Bryceson Shaw Associates

Our Ref.: 2383

The Friends Meeting House, Church Street, Littlehampton.

Proposed First Floor 1:50

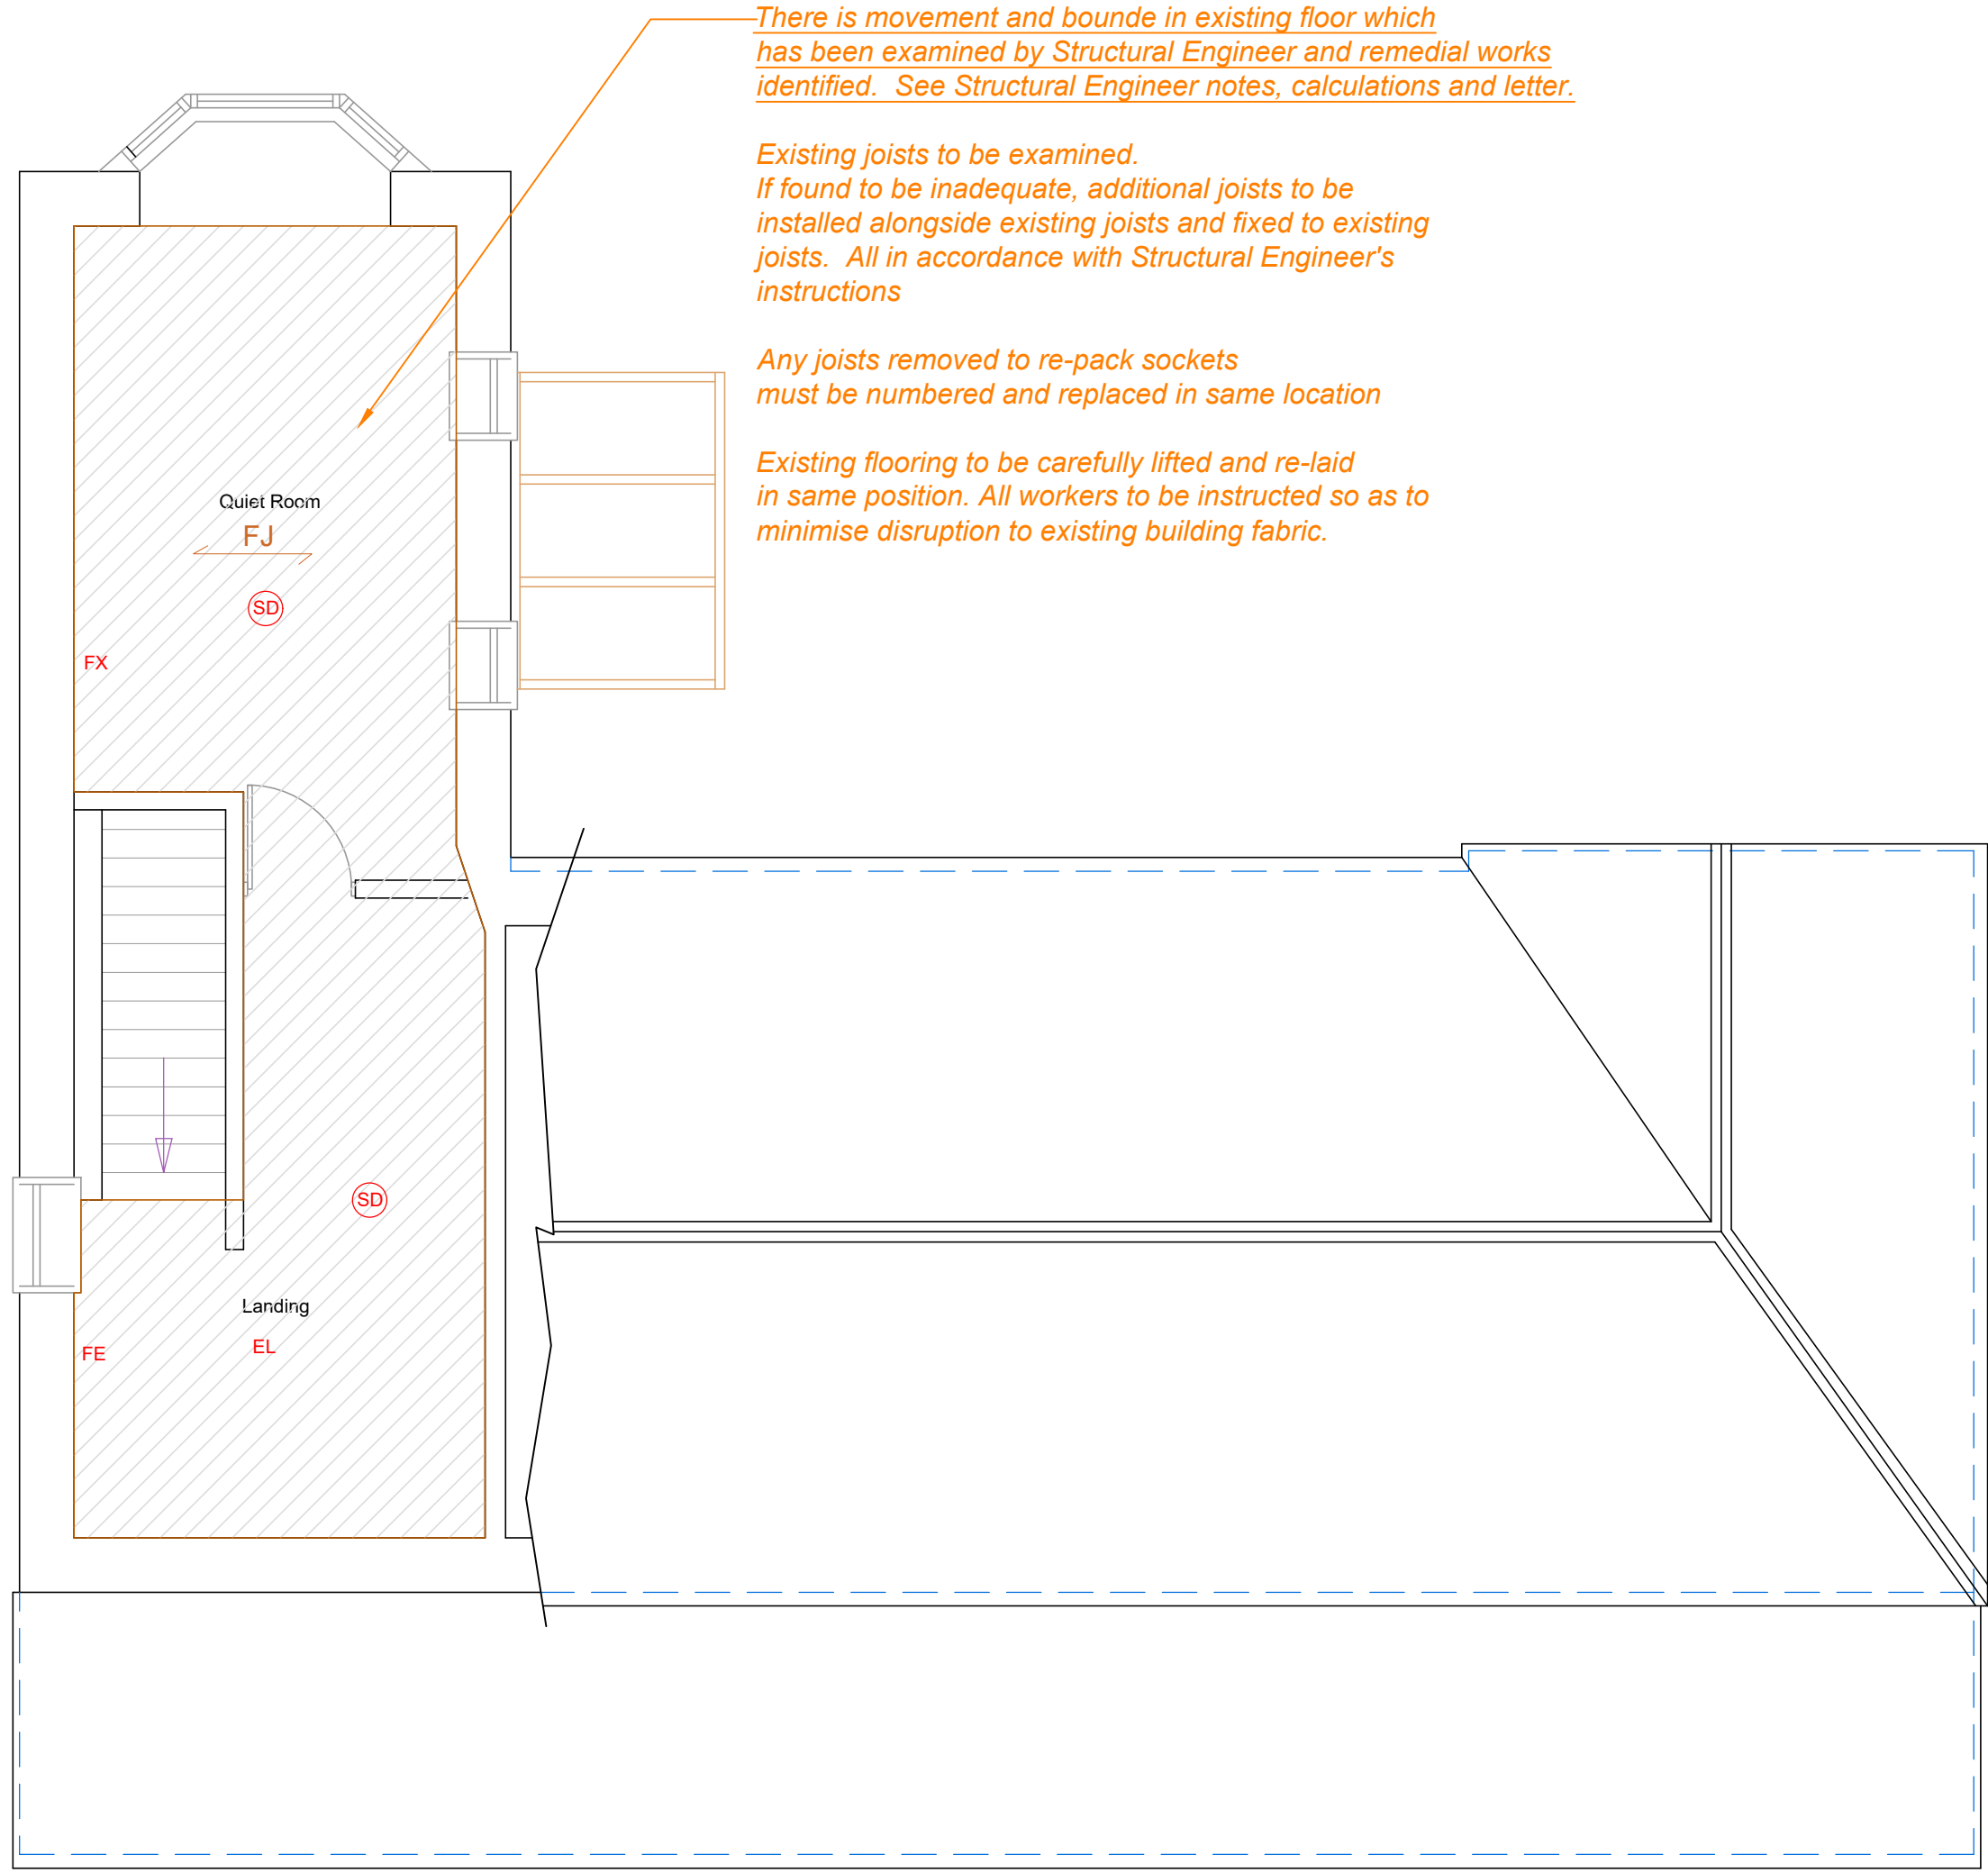
Further to instruction an inspection of the first floor office floor was made to ascertain the cause of excessive deflection. The floor was opened up and the joists are 5x2 inch at 400 centres, calculations show these to be over-spanned hence causing the deflection.

A likely consequence of the movement in the floor is the loosening of the joists in their wall sockets, when the floor is lifted to install the new timber the sockets should be examined and wedged and packed as necessary to tighten the fixings.

As the building is listed I would recommend numbering the floor boards to re-fit them as they lay now in order to preserve the historic fabric.

If the joists are sistered with another 125x47 C24 timber then they are able to carry the design load. It is not necessary for the new timbers to be built into the walls.
